APPLICATION BY NATIONAL GRID ELECTRICITY TRANSMISSION FOR AN ORDER GRANTING DEVELOPMENT CONSENT FOR SEA LINK

PINS REFERENCE: EN020026

**SUBMISSIONS ON BEHALF OF SAVE MINSTER MARSHES
FOR DEADLINE 7**

Plate 2.4 Potential floodplain compensation provision locations

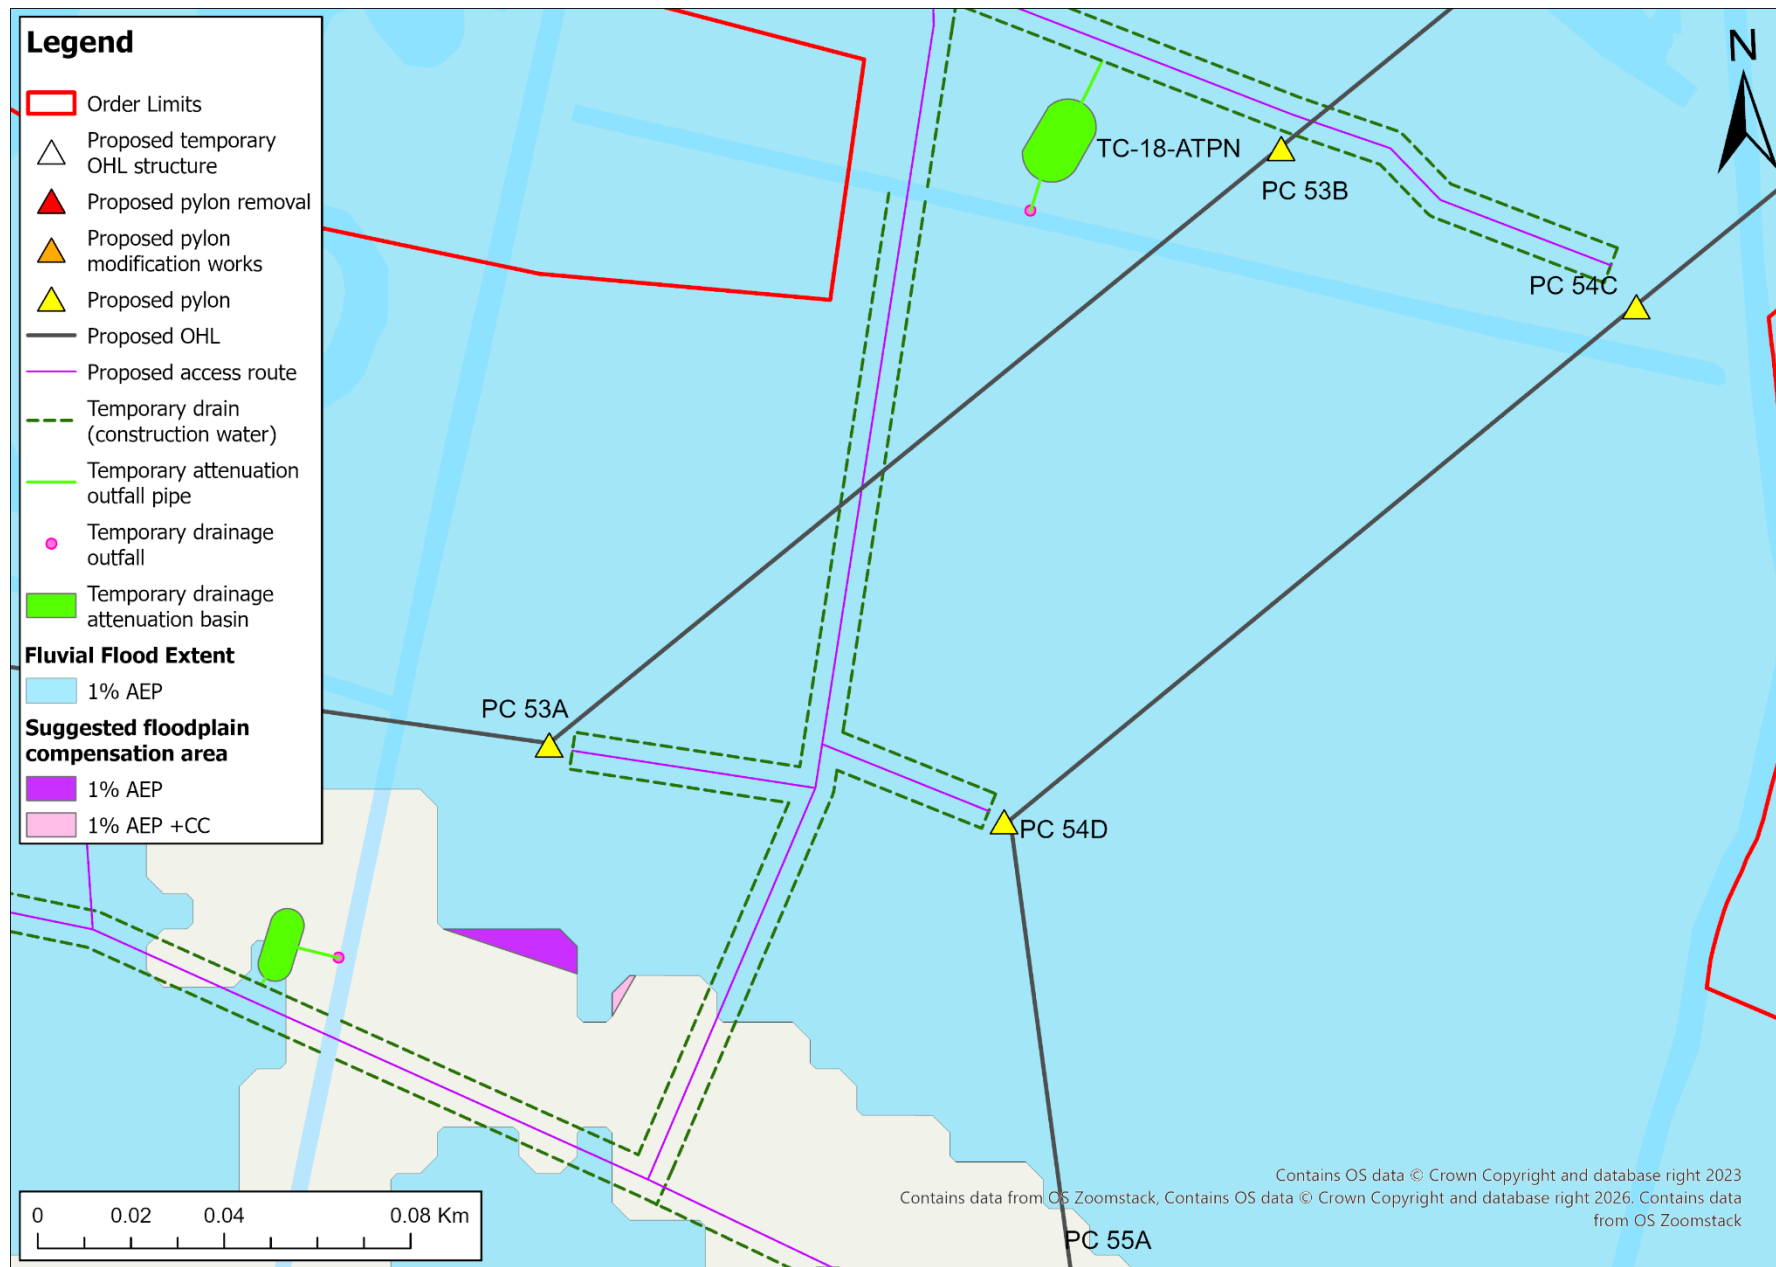
9. In para 2.3.2 of REP6-093, Document 9.101: Kent Onshore Scheme – Fluvial Flooding from the River Stour, the Applicant states “the regulator’s position (the EA) is that any loss of fluvial floodplain storage should be compensated for. Floodplain compensation may be delivered in a range of ways, a typical example being to lower an area of land that is hydraulically connected to the same floodplain cell in which the losses occur, to re-provide storage on a volume for volume basis as a minimum” and goes on to state that this will be committed to in the REAC in W35. This currently states that it will be committed to in consultation with the Environmental Agency and will be explained in the “Floodplain Compensation Strategy detailed in the Drainage Management Plan”. Although new documents have been submitted – we cannot see that an up-to-date Drainage Management Plan has been submitted for further consideration.
